Application No: BE/59/21/PL
Site Address: 339 Chichester Road Bersted PO21 5AN
Description of works: Replacement of blockwork boundary wall with fence and new vehicular access (resubmission of BE/149/21/PL).

Thank you for your internet representation made on 7th May 2021 which has been recorded as an objection with the comments as follows:

OWPC35833

SITE PLAN - SHOWING VISIBILITY SPLAYS
1:500 SCALE (at A3)

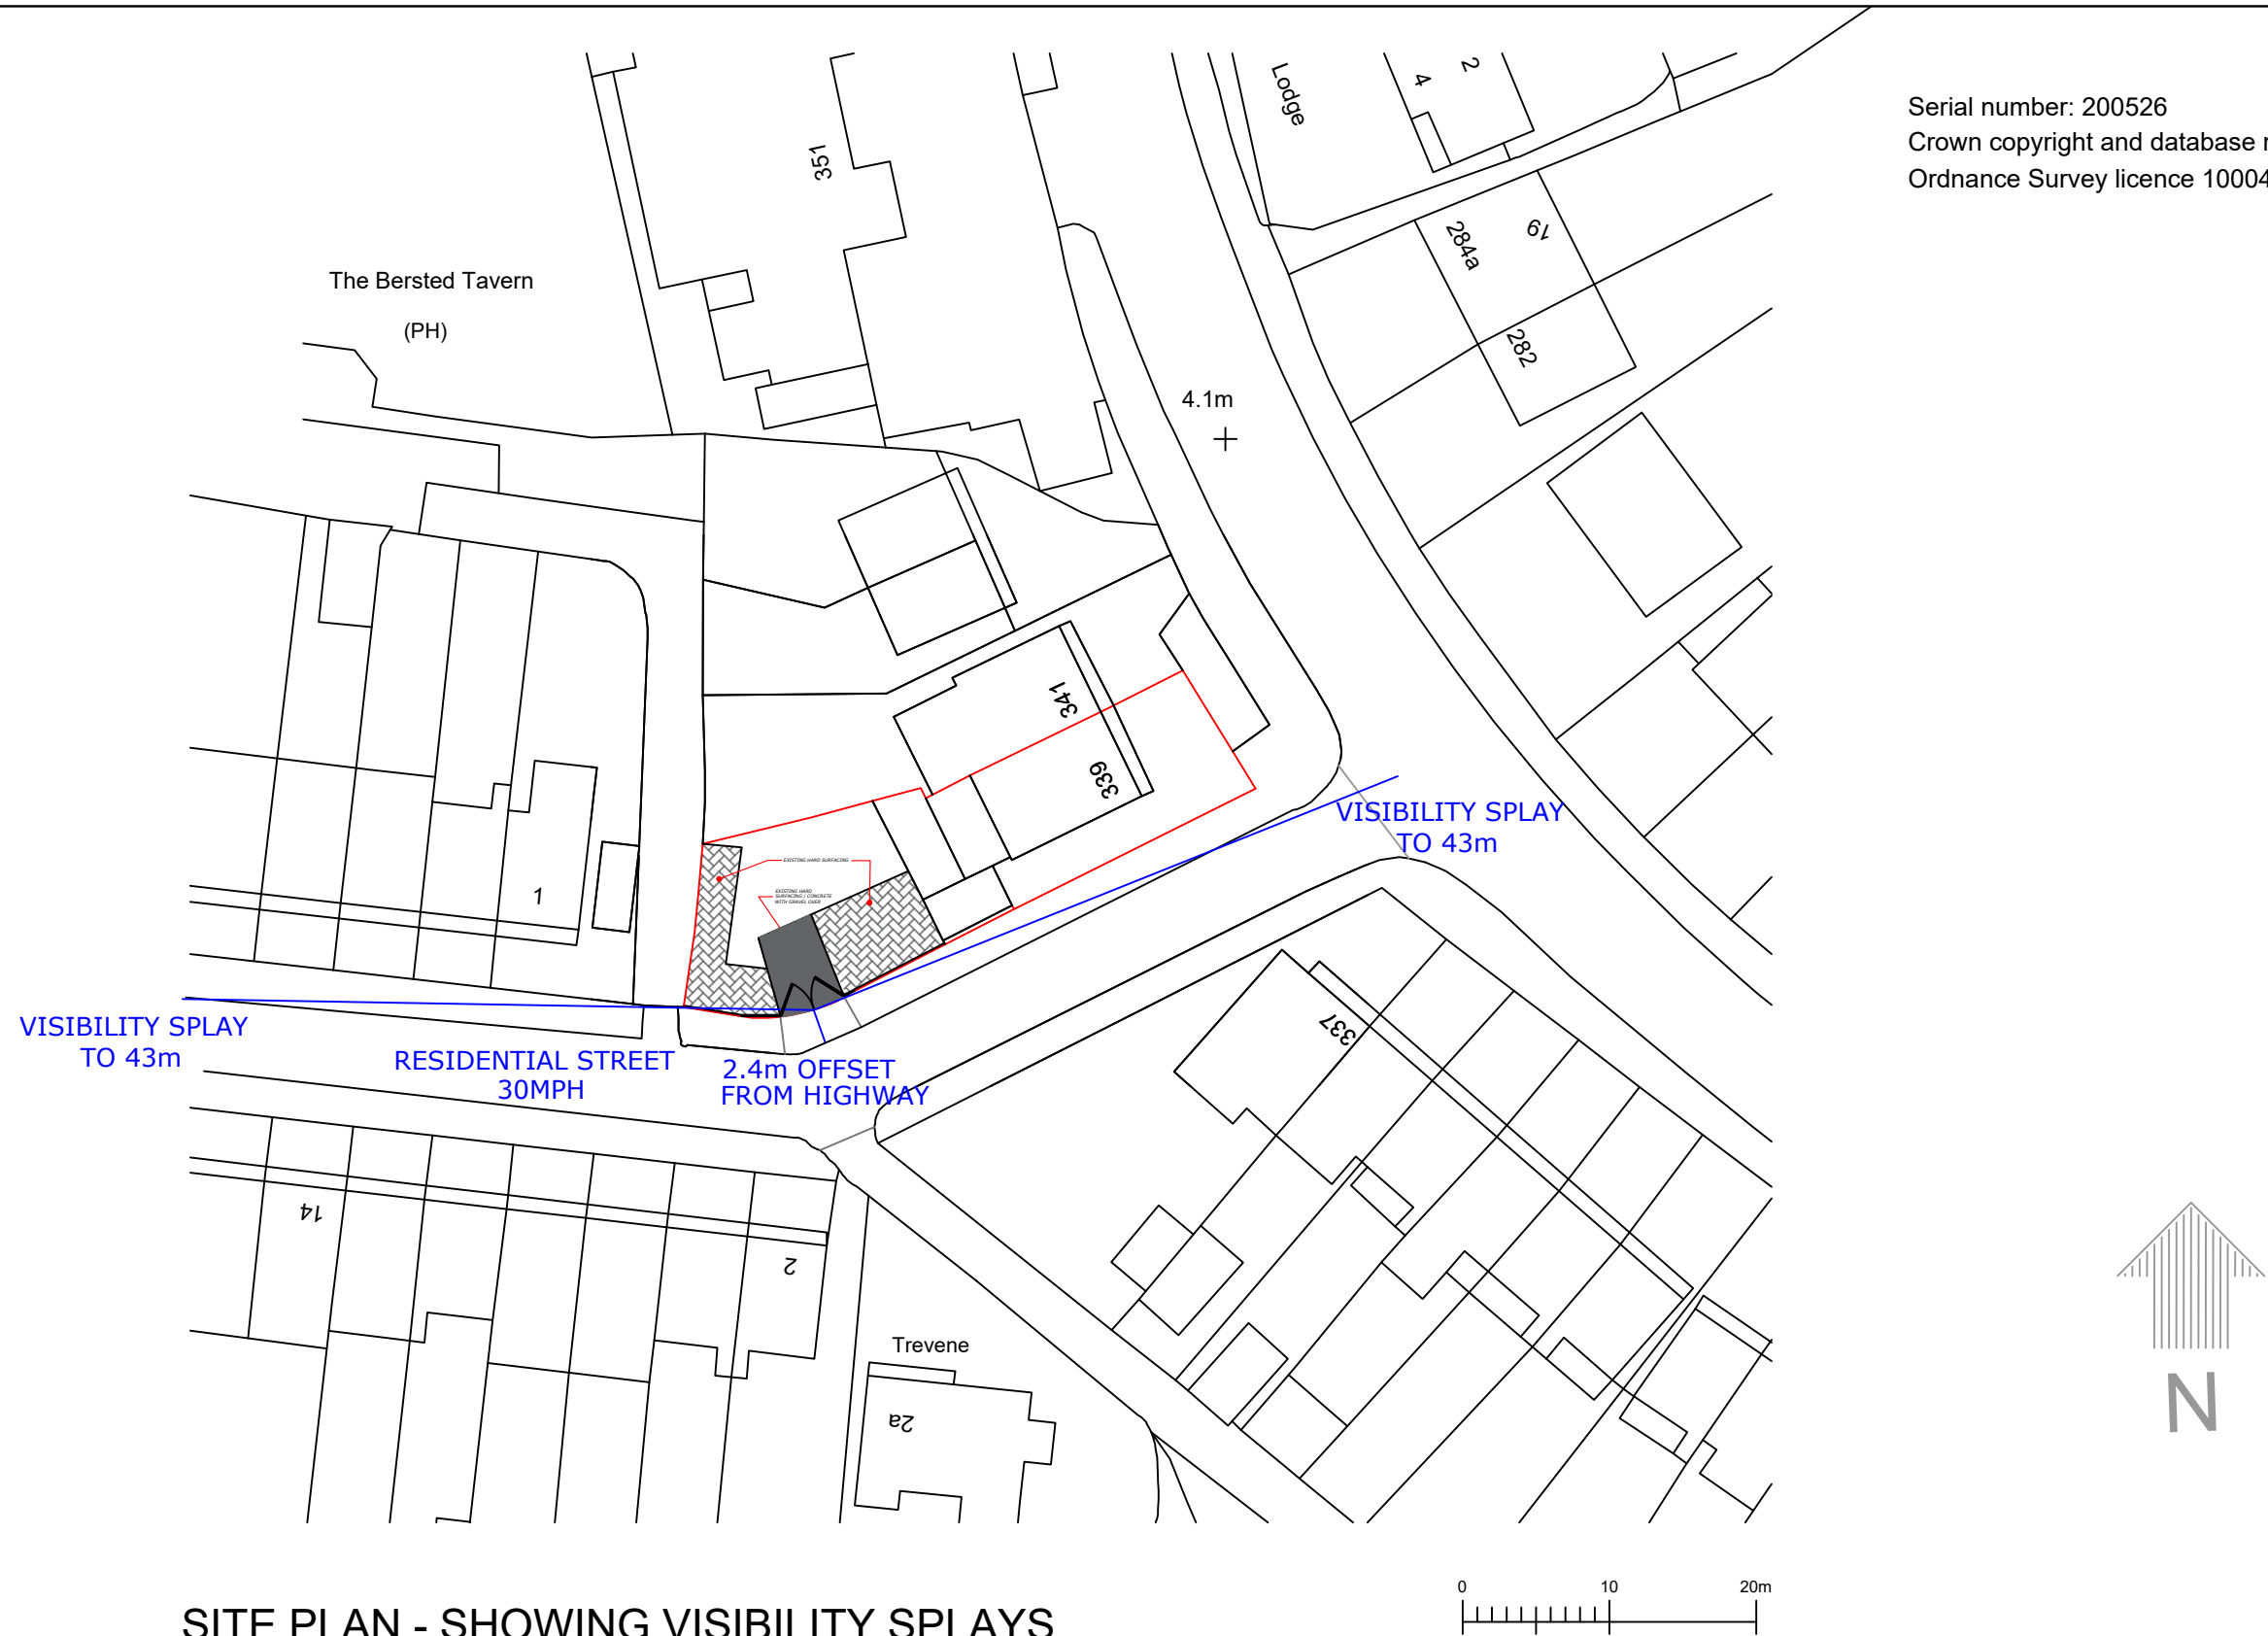
The proposal for a vehicle crossover, and off road parking, is unacceptable bearing in mind the requirements in respect of viability splays which cannot be met for lots of reasons including parked cars and a tree within the sight lines.
